## Design Response to SOPA Issues

Project No: 11002  
Project: **3 Murray Rose Avenue**  
Date: 25 January 2013

### Design Response to SOPA Issues: Depth of Building Recesses & the Width of Public Pathways

1 Lower Level 'The Chase'
1:100

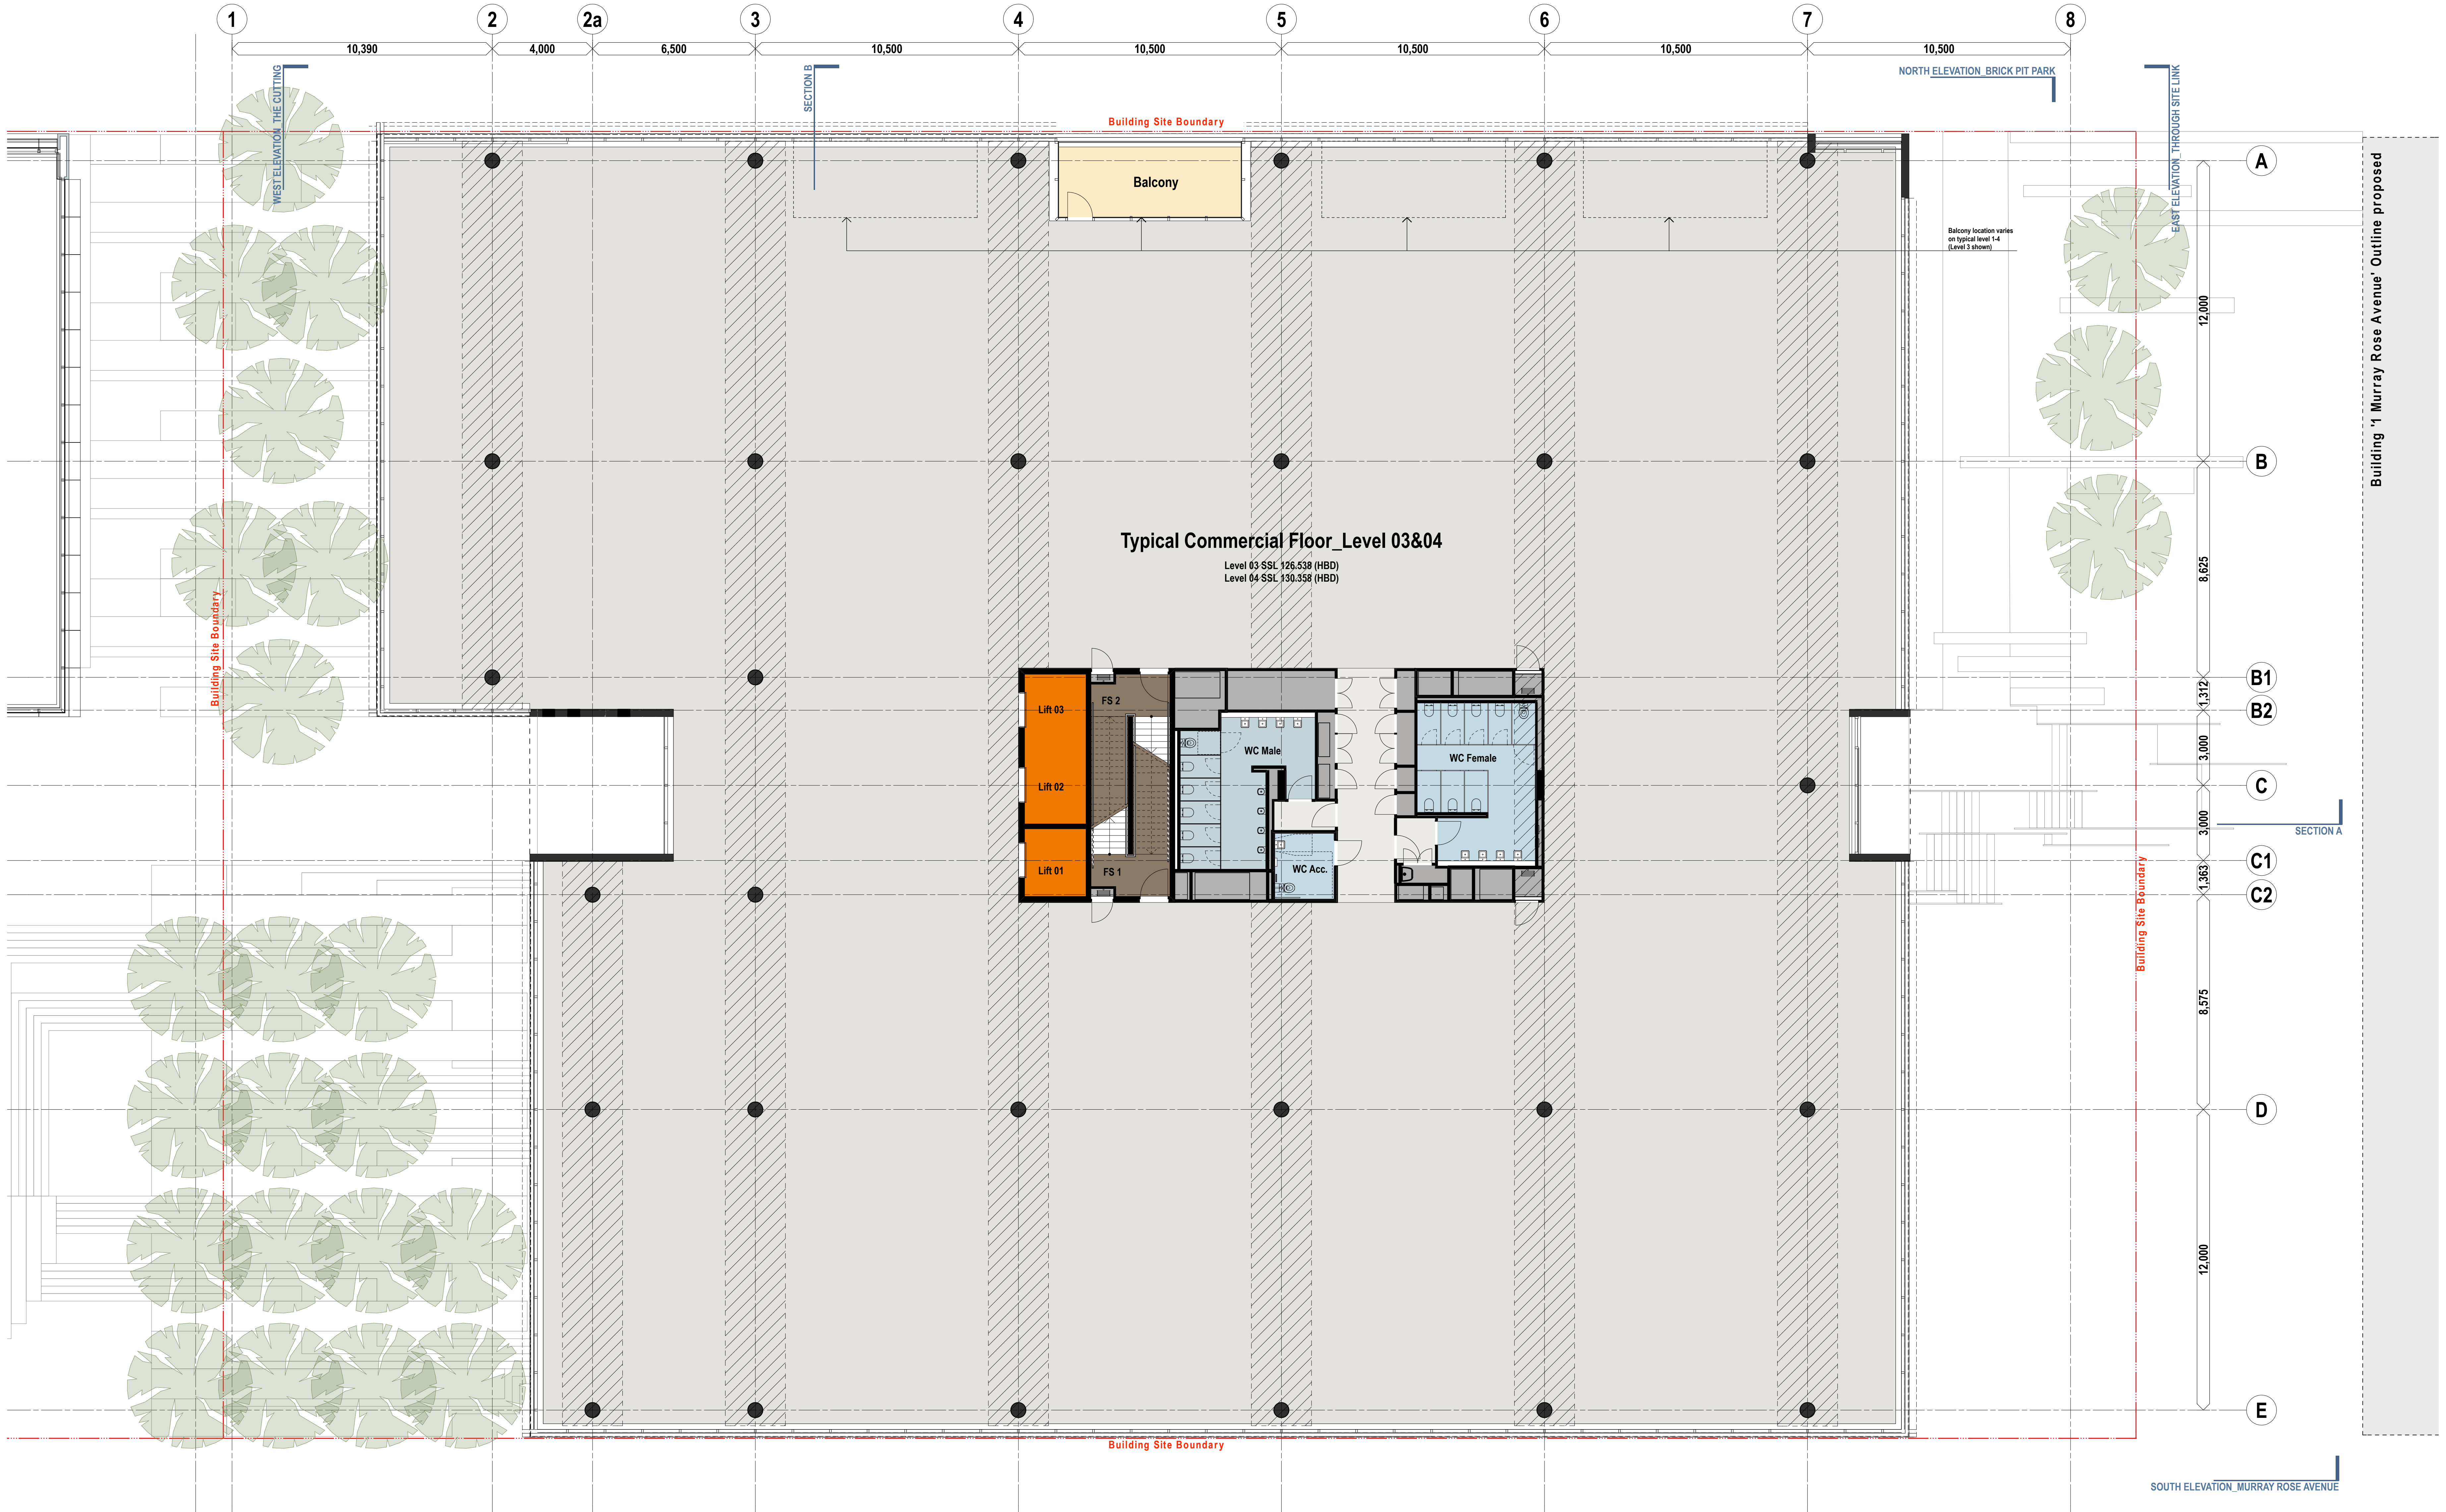
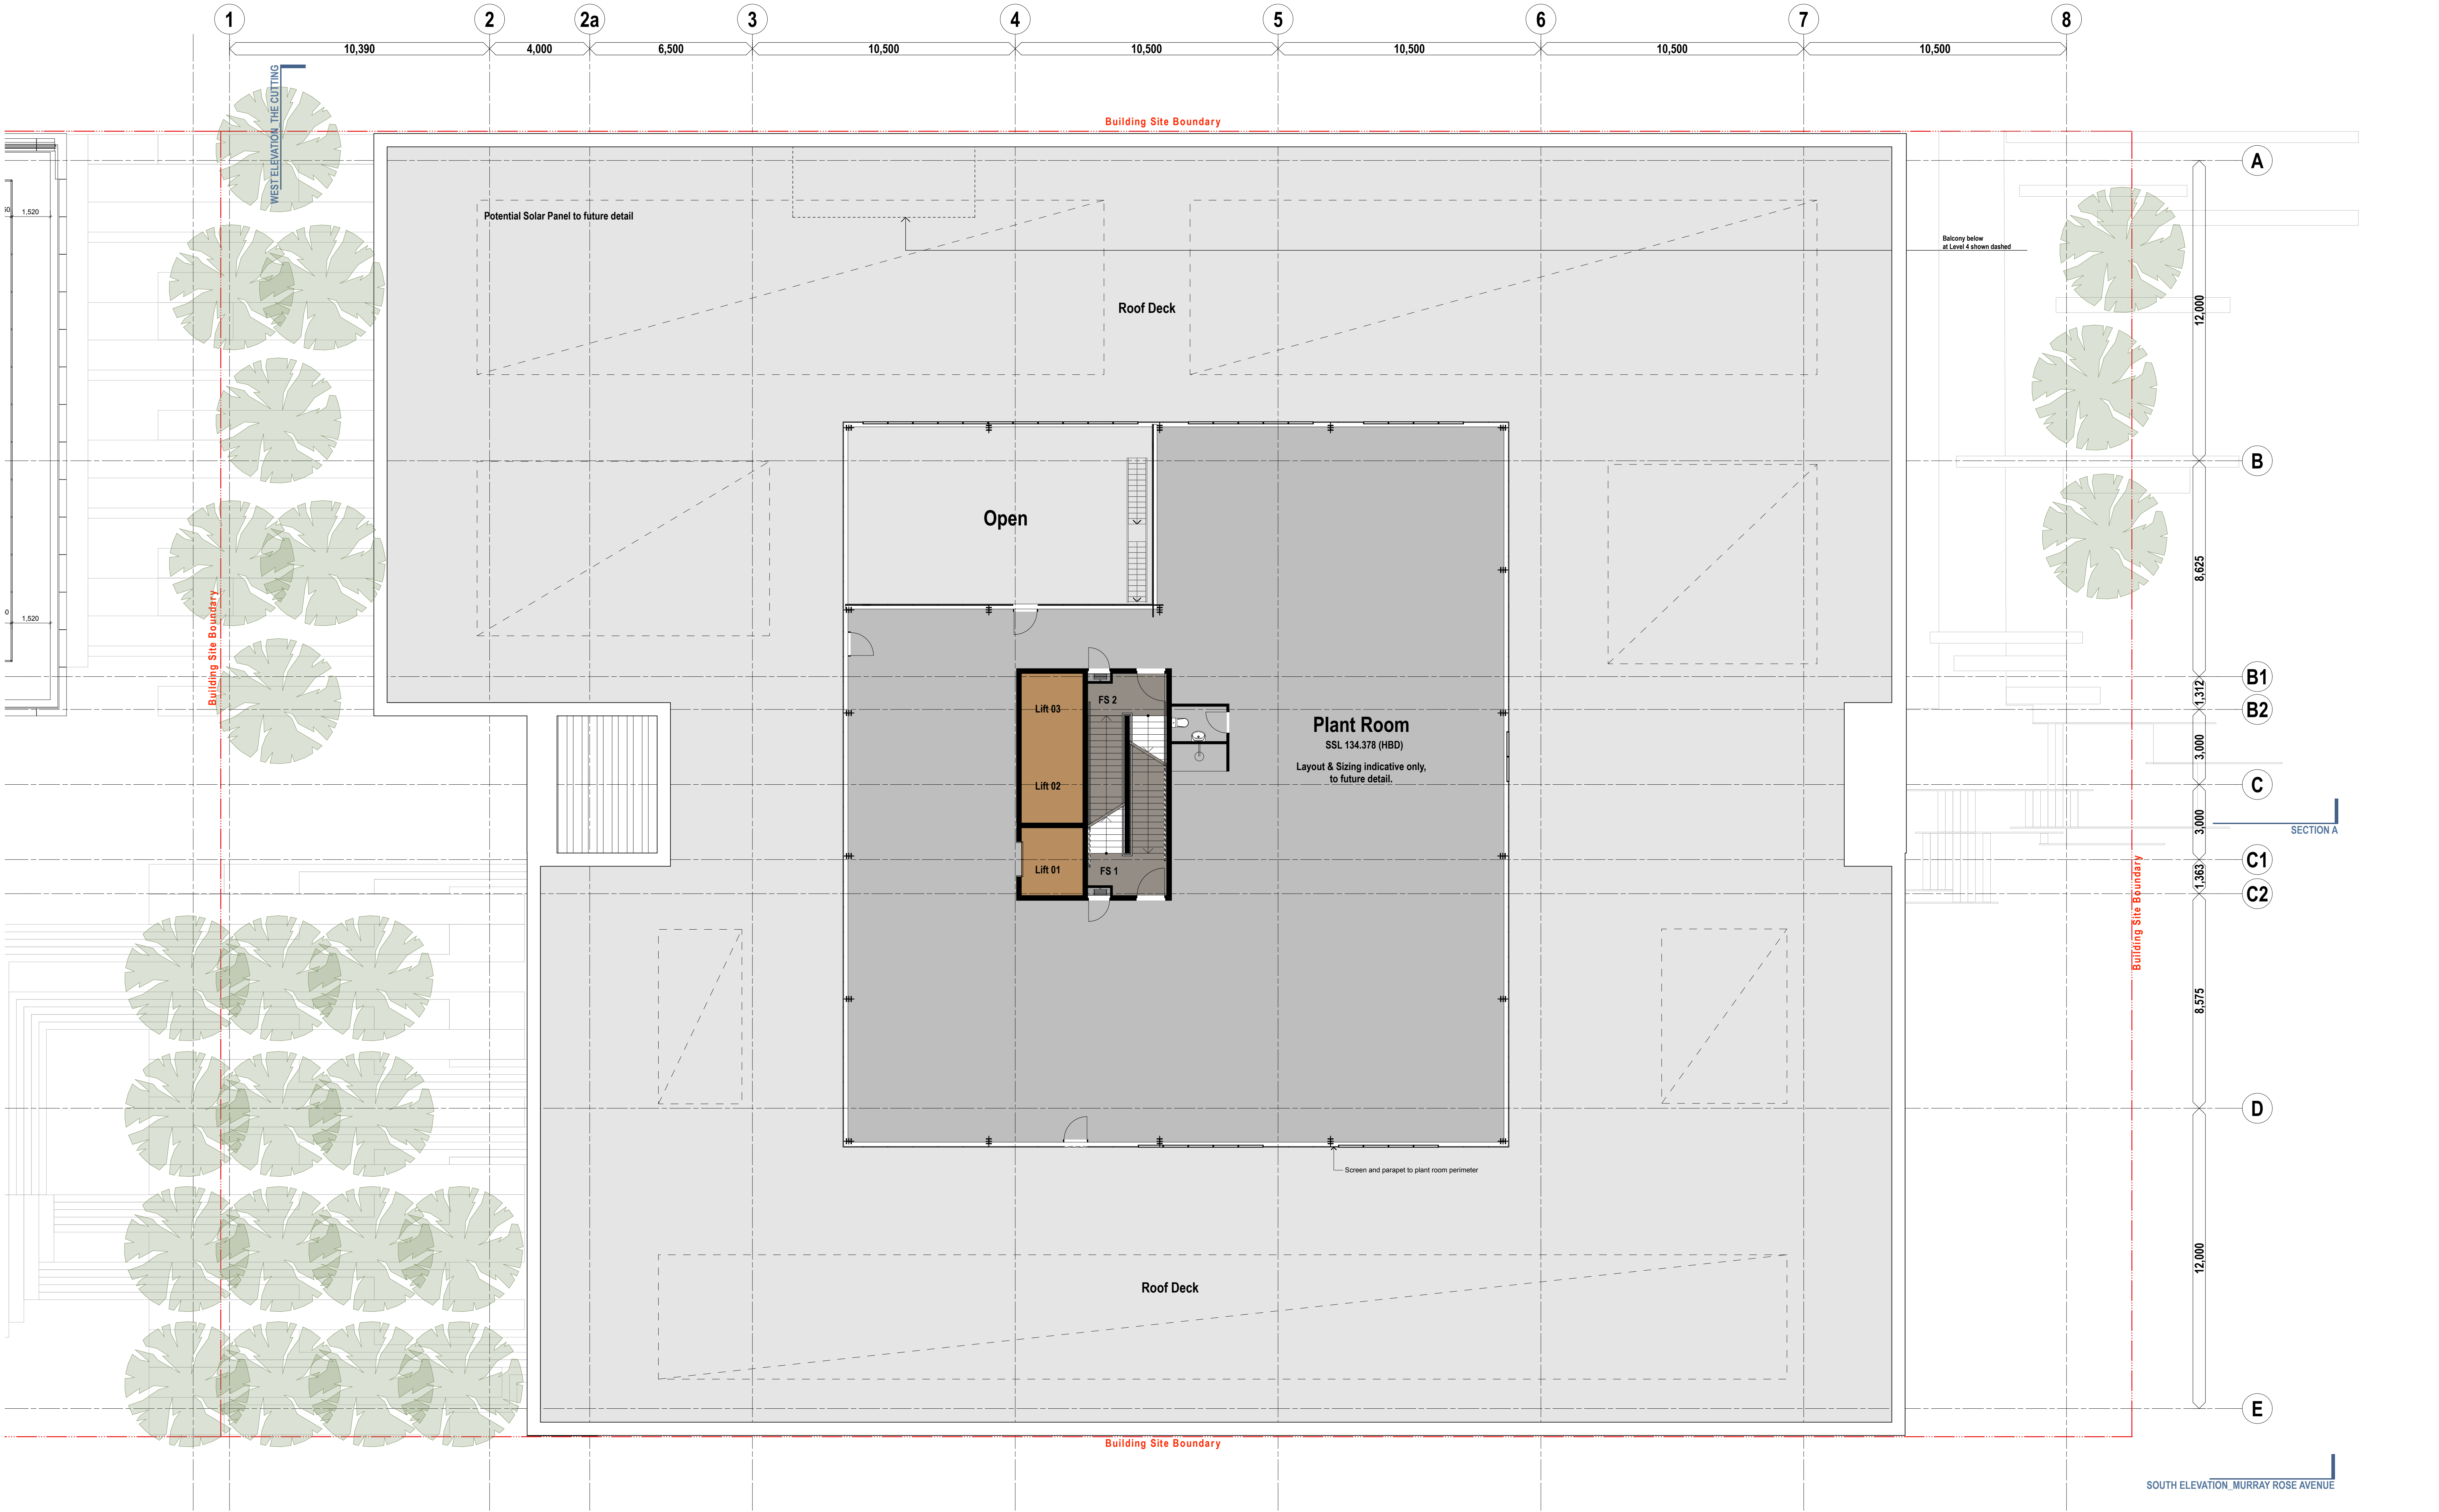
The immediate context, represents only half of 'The Chase', relying on the future development No.1 Murray Rose Avenue to complete this public domain space. Architectural drawings EA108 and EA109 show both immediate and ideas for the future design of 'The Chase'.

When consideration is given to the future design ideas, a publicly accessible pathway, well in excess of 2.0m can be achieved, not to mention significant landscaping and shared drop off / service area for both buildings. However, the immediate context - only half of 'The Chase' - limits the immediate realisation for all of these opportunities. With reference to SOPA correspondence -

the width of the publicly accessible pathway.

Despite this short term restriction the objectives for 'The Cutting' are still achieved avoiding a perfunctory response. The minor numerical variation in the width of the pathway is inconsequential when consideration is given to the overall development of 'The Chase' when complete.

As detailed above we strongly believe that the building recess and the width of public pathway is appropriate with consideration to both the immediate and future context for the site and precinct.
